Your reference: SSD-7942 MOD 1

**RESPONSE TO EXHIBITION STATE SIGNIFICANT DEVELOPMENT 7942-MOD-1  
Construction and operation of an open water surf sports lagoon facility  
Pod B, P5 Car Park, Hill Road, Sydney Olympic Park (Lot 71 DP 1191648)**

LEGEND

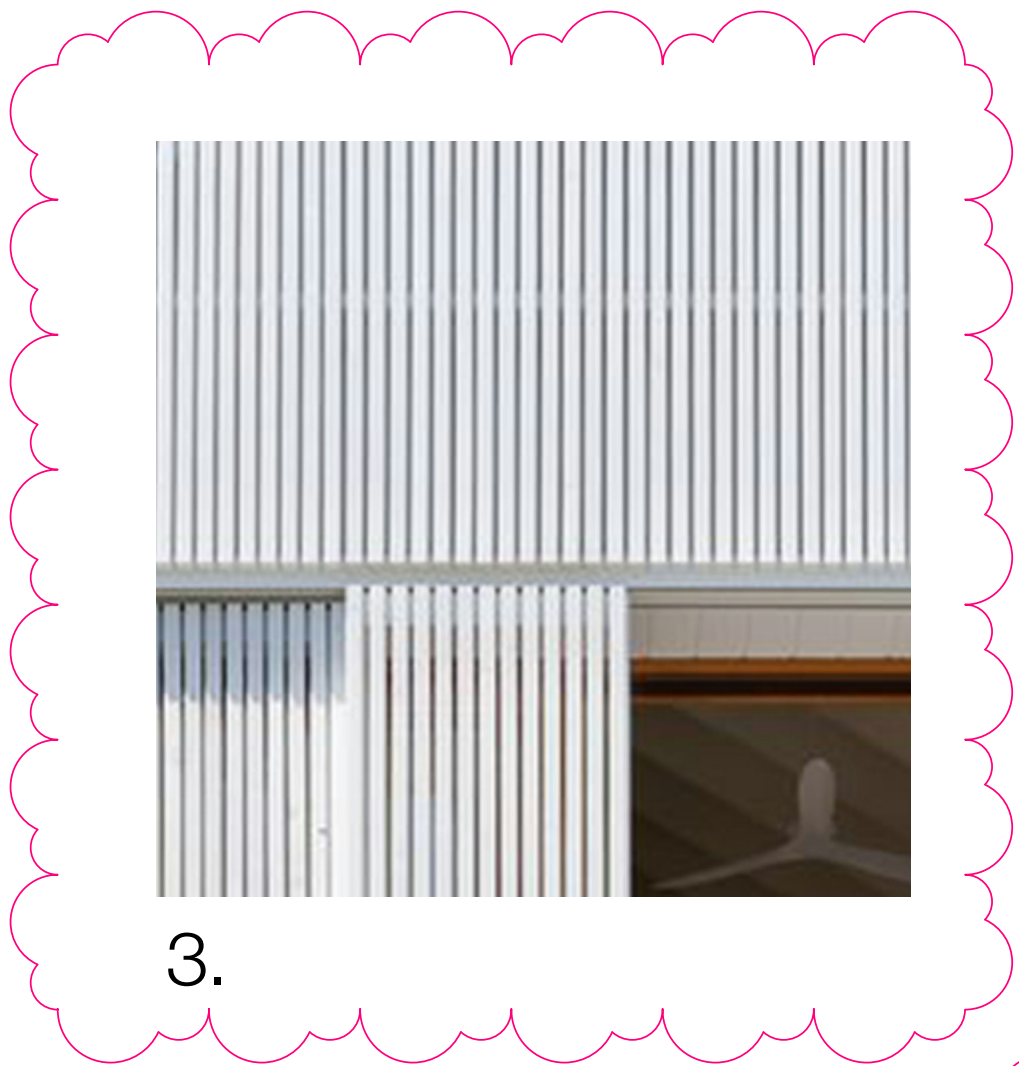
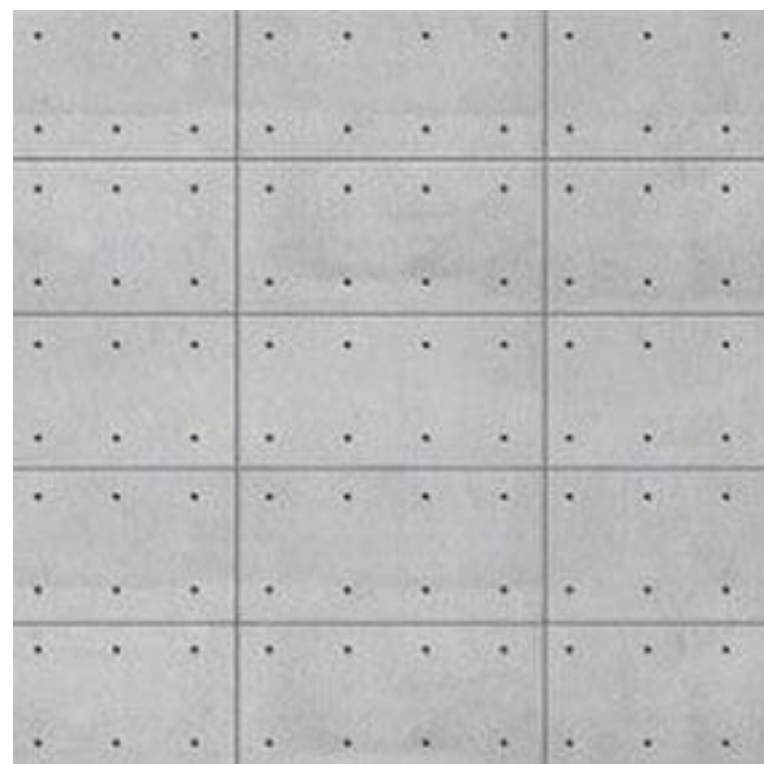
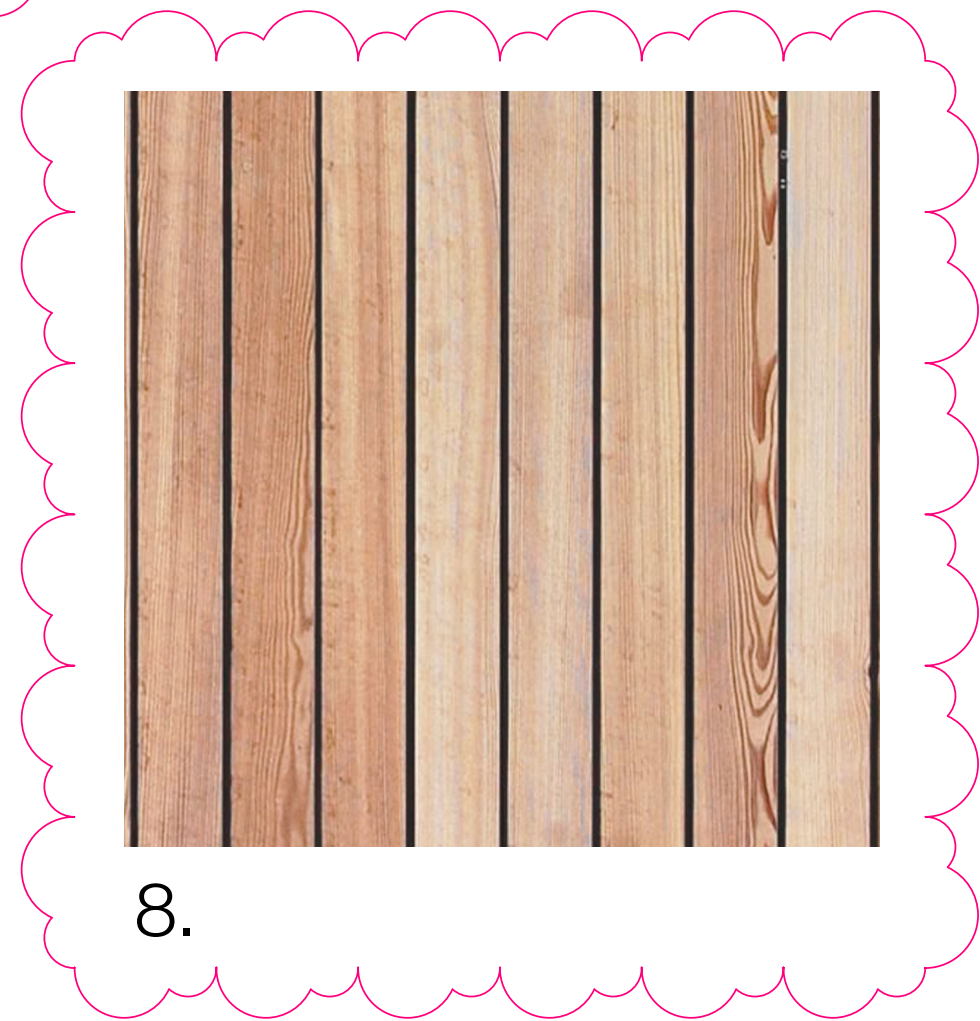
However, SOPA considers that the materiality and colour of the proposed building facade, given the location of the development site within Sydney Olympic Park Parklands, should be more reflective of the site's location and incorporate natural materials and neutral colours. In particular, the dark tones and large amounts of the proposed modified cladding and loss of the warm-toned timber cladding is not appropriate to the setting.

Accordingly, SOPA considers the modified design in relation to materials and colours of the façade are unacceptable and the original colours and materials should be revisited.
